**Timbers at Black Forest
Letter of Intent**

February 23, 2026

Tax Schedule No: 5222000025
Acreage: 55.707 acres
Current Zoning: RR-5 (Residential Rural)
Requested Zoning: RR-2.5 (Residential Rural)

Vertex Consulting Services, LLC, on behalf of Michael Turner, is respectfully submitting an application for a map amendment (rezone) from the RR-5 zoning district to the RR-2.5 zoning district. A concurrent request has been submitted to subdivide the land into 21 lots. The proposed rezone is compatible with the surrounding planned and existing developments and is consistent with the Your El Paso Master Plan.

Below is a map depicting the surrounding development and zoning:

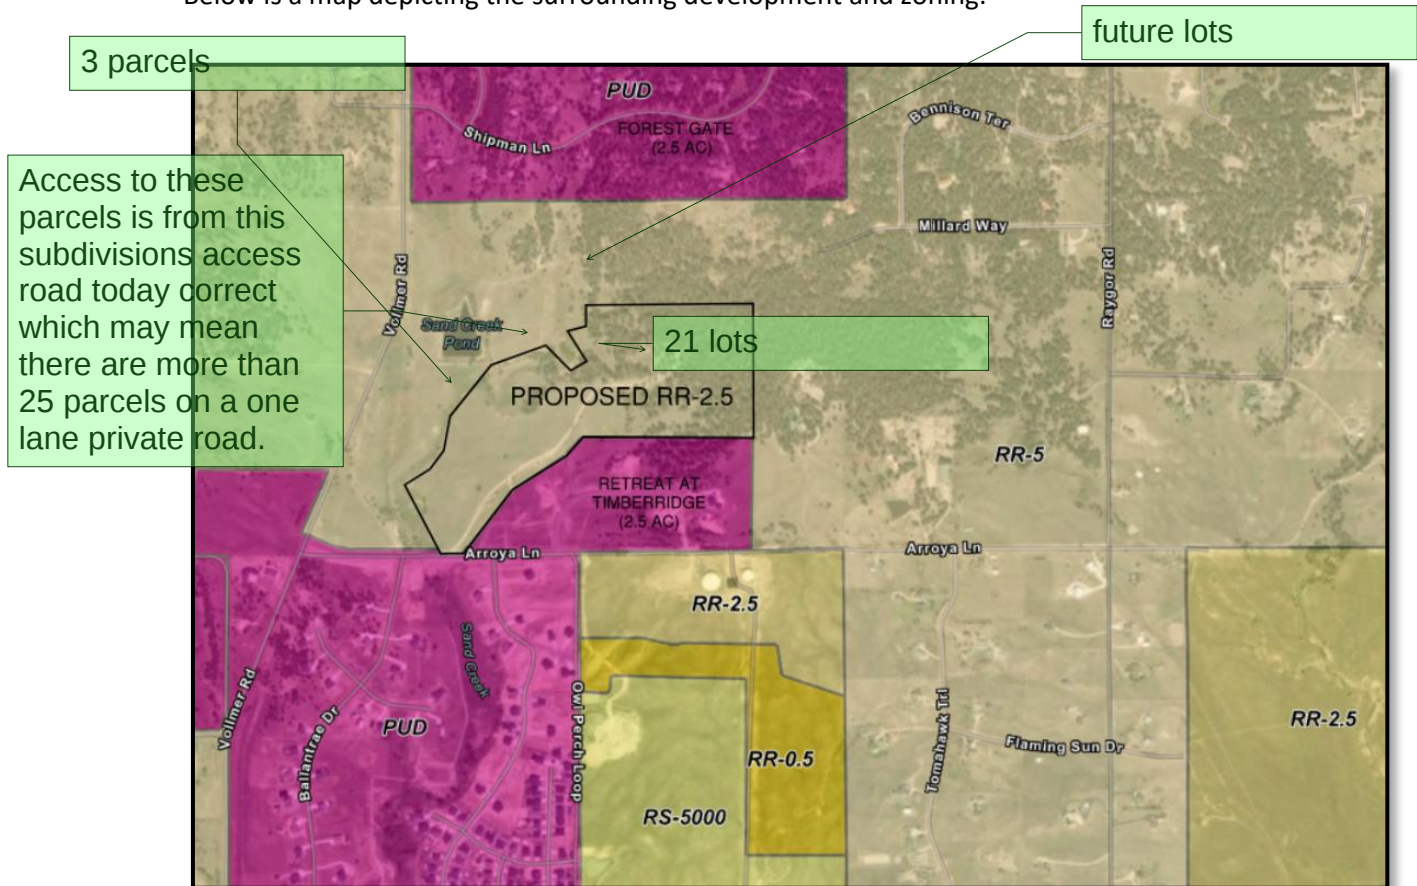
Per the applicants statement- connectivity through the site to adjacent properties should be identified as cited in LDC . The creek limits access to the west.

Access to these parcels is from this subdivisions access road today correct which may mean there are more than 25 parcels on a one lane private road.

Response: discussed in meeting 9/1/26. the adjacent lots have access to both Arroya as well as Shipman Lane. It was determined this comment does not apply.

Response: deeds and surveys were provided to EPC to clear up any confusion regarding the parcel configuration. these comments were discussed in meeting 9/1/26. the adjacent lots have access to both Arroya as well as Shipman Lane. It was determined this comment does not apply.
